JCE Project No. 2023-05-19

26 September 2024

Re: Layout Change – 2098 Elliott Bridge Road Bunnlevel, NC

PLAN NORTH  
**1** BLDG-1 PLUMBING - WATER  
 P3 NEW SECOND FLOOR  
 SCALE: 1/4" = 1'-0"

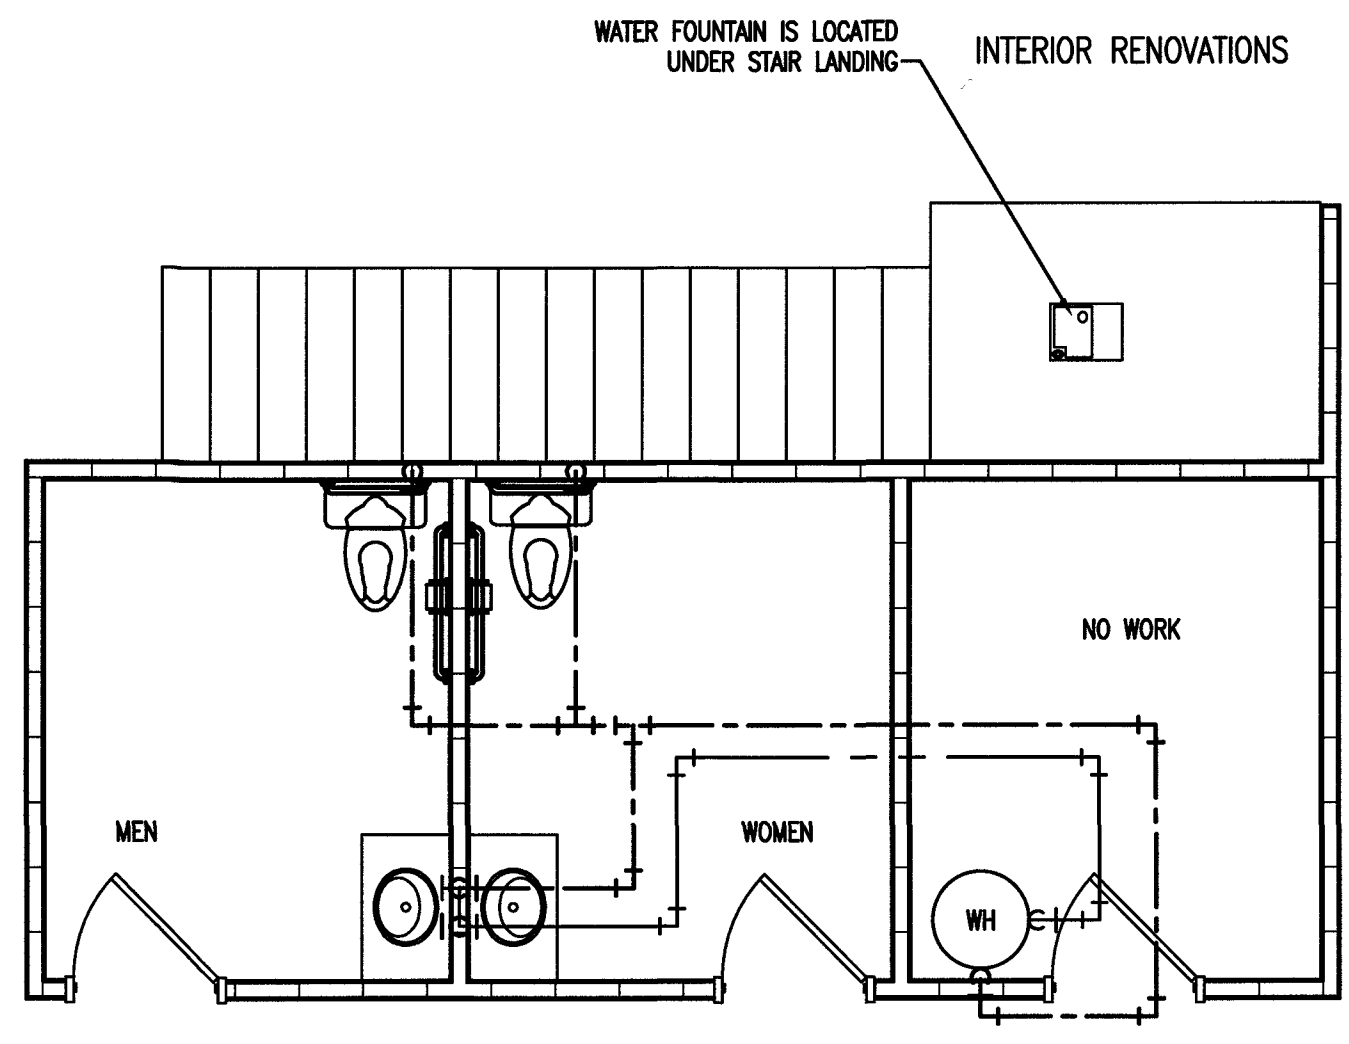
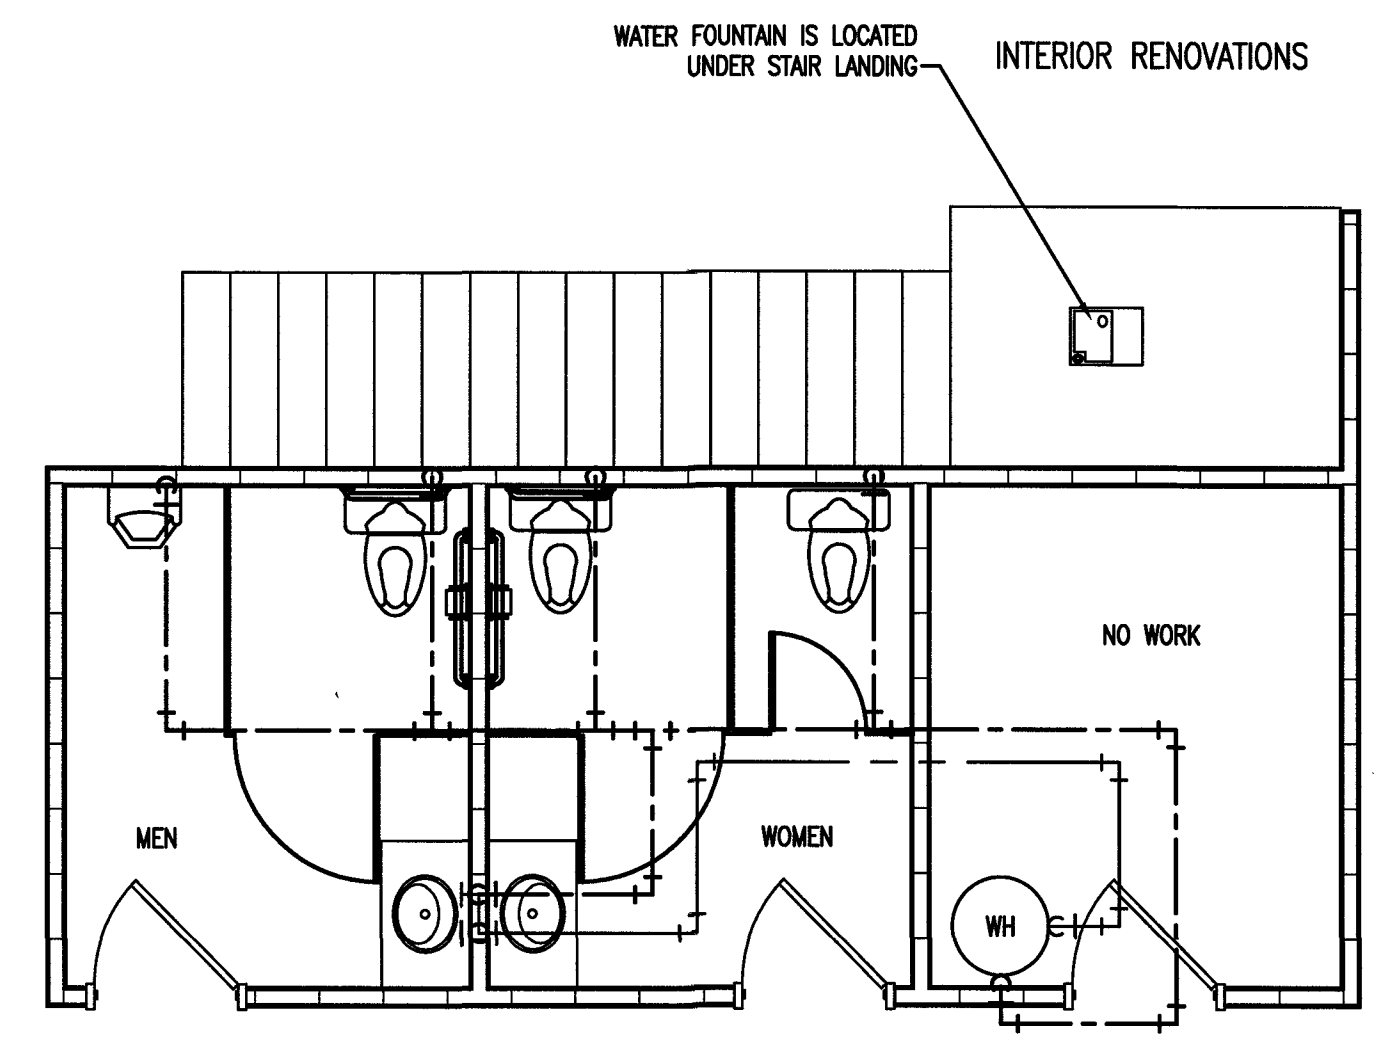
Due to an unforeseen structural beam preventing the contractor from installing an opening in a wall, the layout of the upstairs restroom area has changed slightly. A wall that led into the original restroom was brought out roughly 2'7". This change will allow for access to a shut-off valve for the shower and will provide an area for shelving within the space. The existing kitchen is being used as a second restroom, but no walls or doors are affected with this change.
